Application for a non-material amendment following a grant of planning permission.

ERECTION OF SINGLE STOREY SIDE/REAR
EXTENSIONS TO BOTH SIDES OF BUNGALOW

2017/0775

CHANGING EXTENSION ROOF'S FROM GABLES TO
HIPS

Drg No 17 | 77 | B Rev B

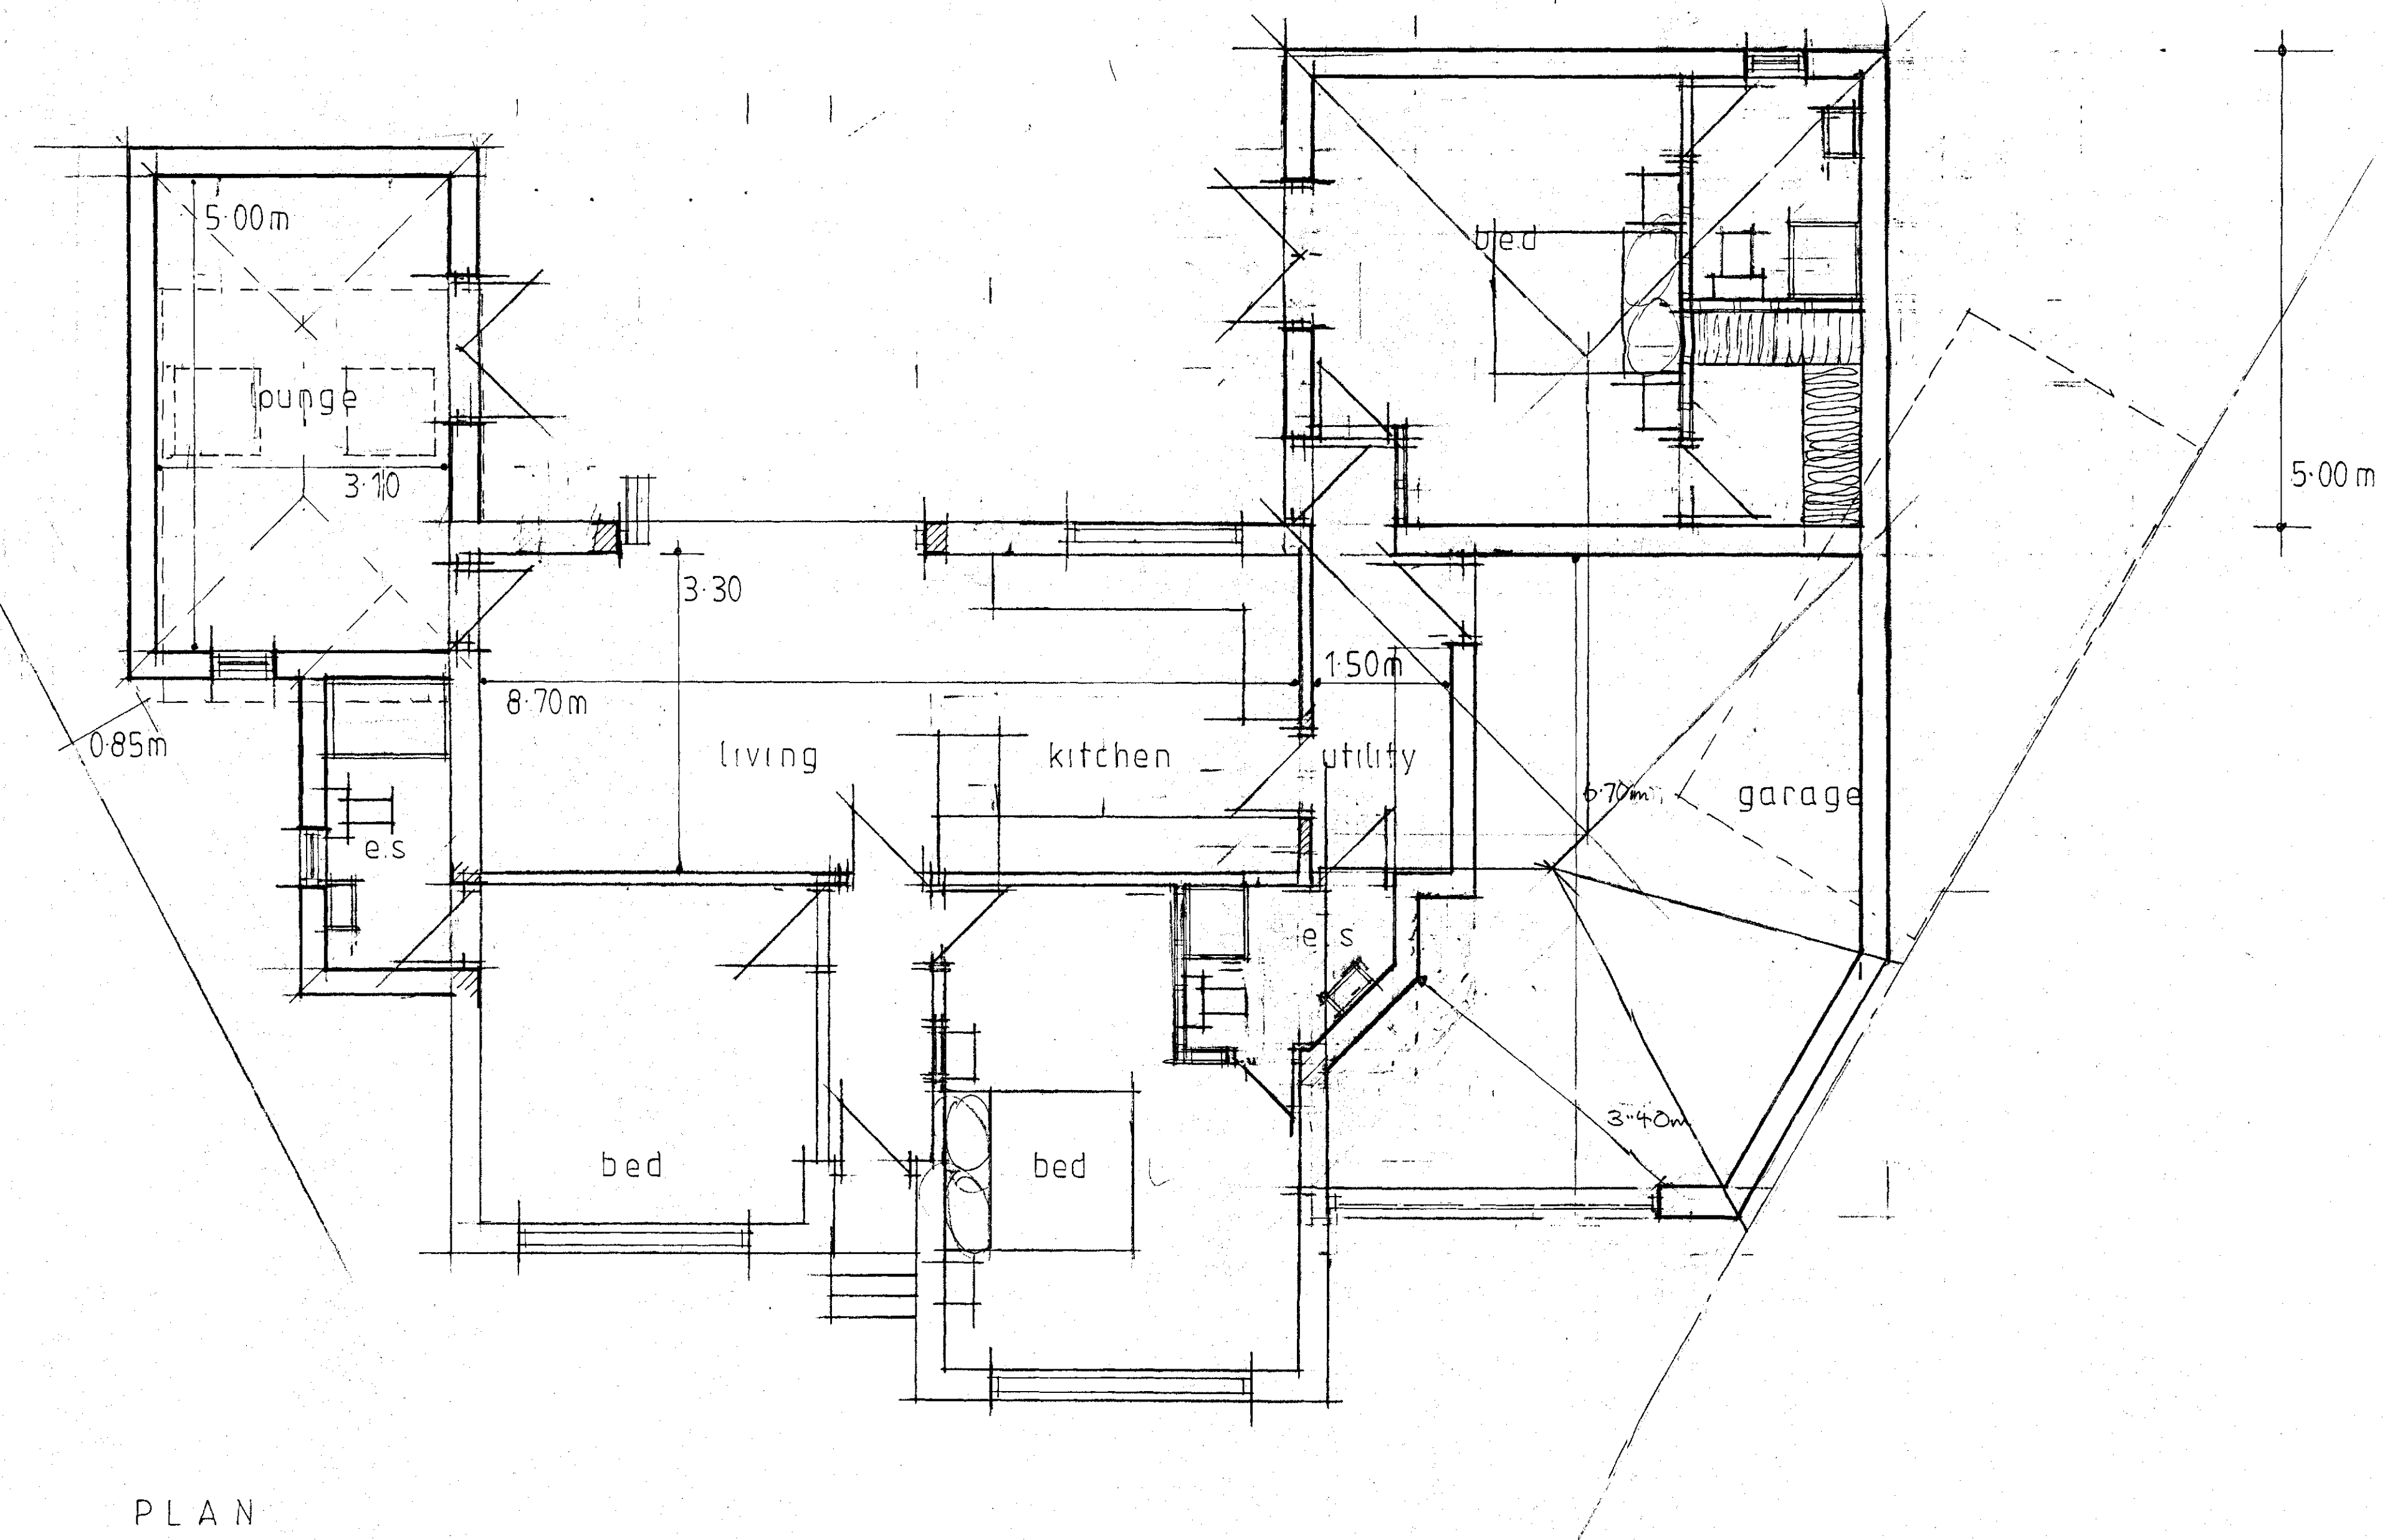
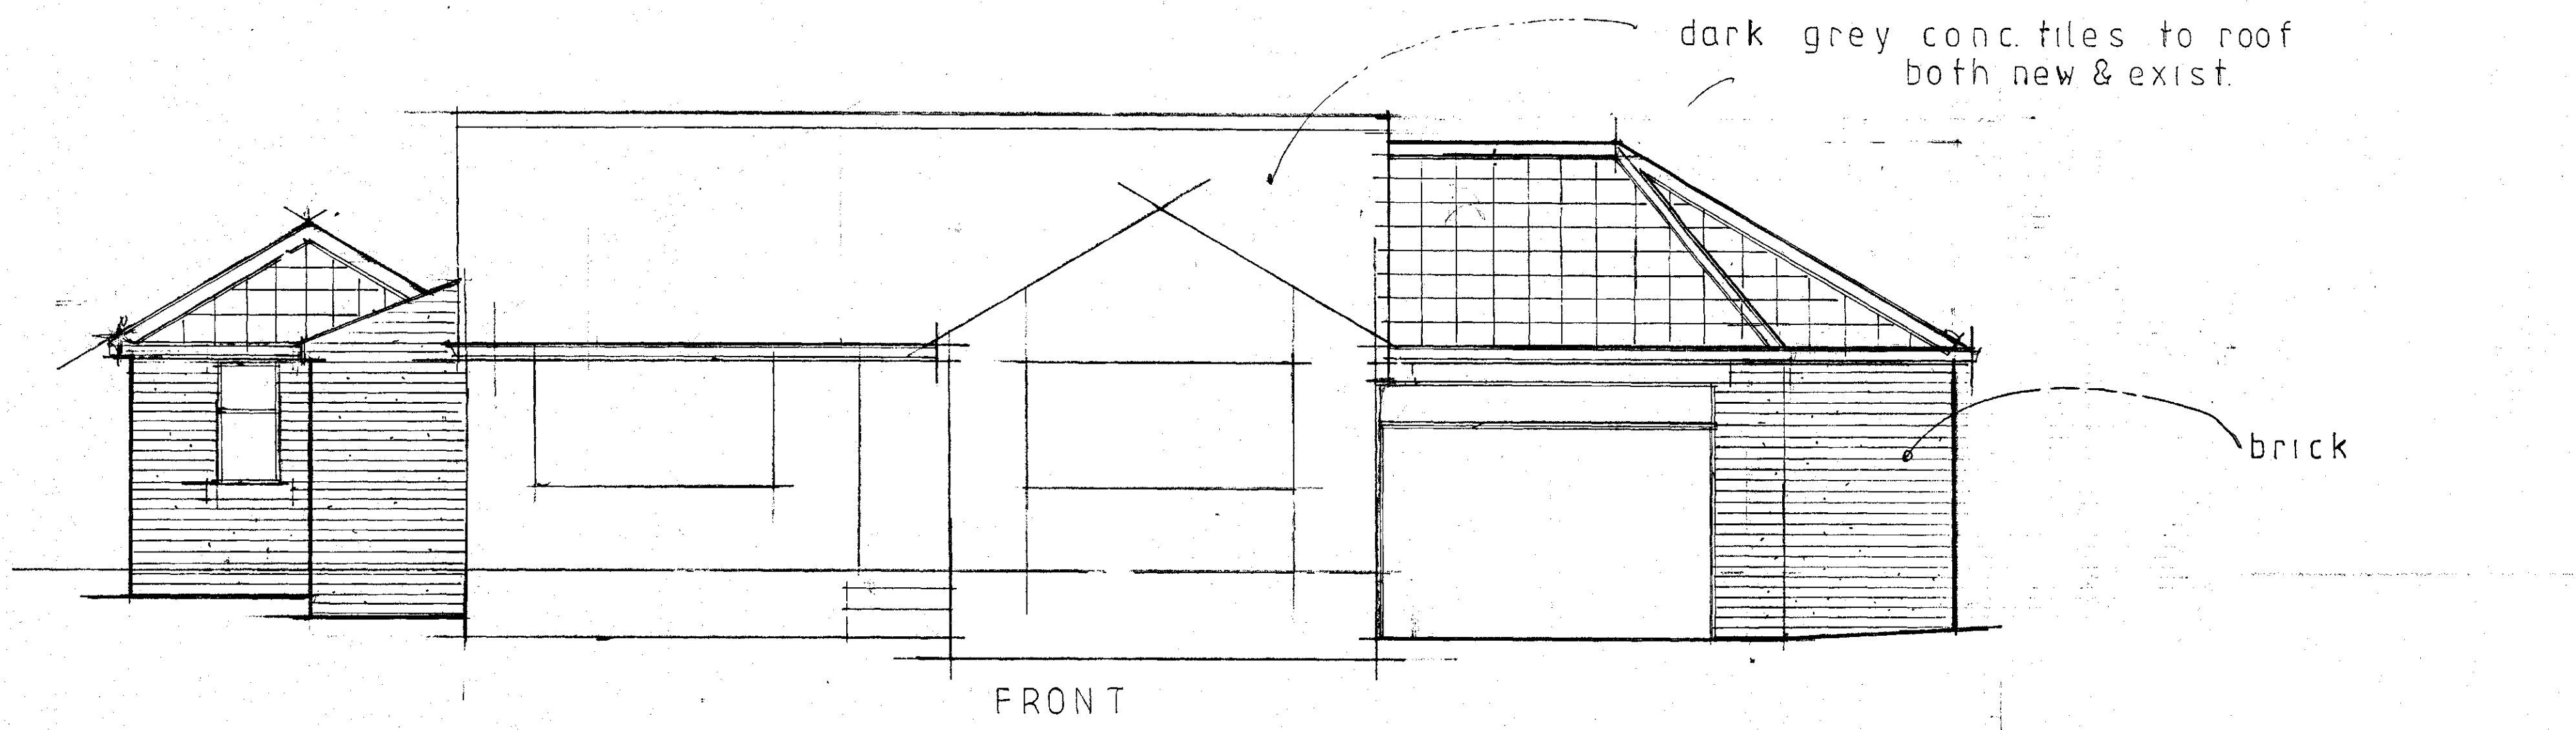
17/77/B rev A 17/77/C rev A

17/77/B rev B 17/77/C rev B
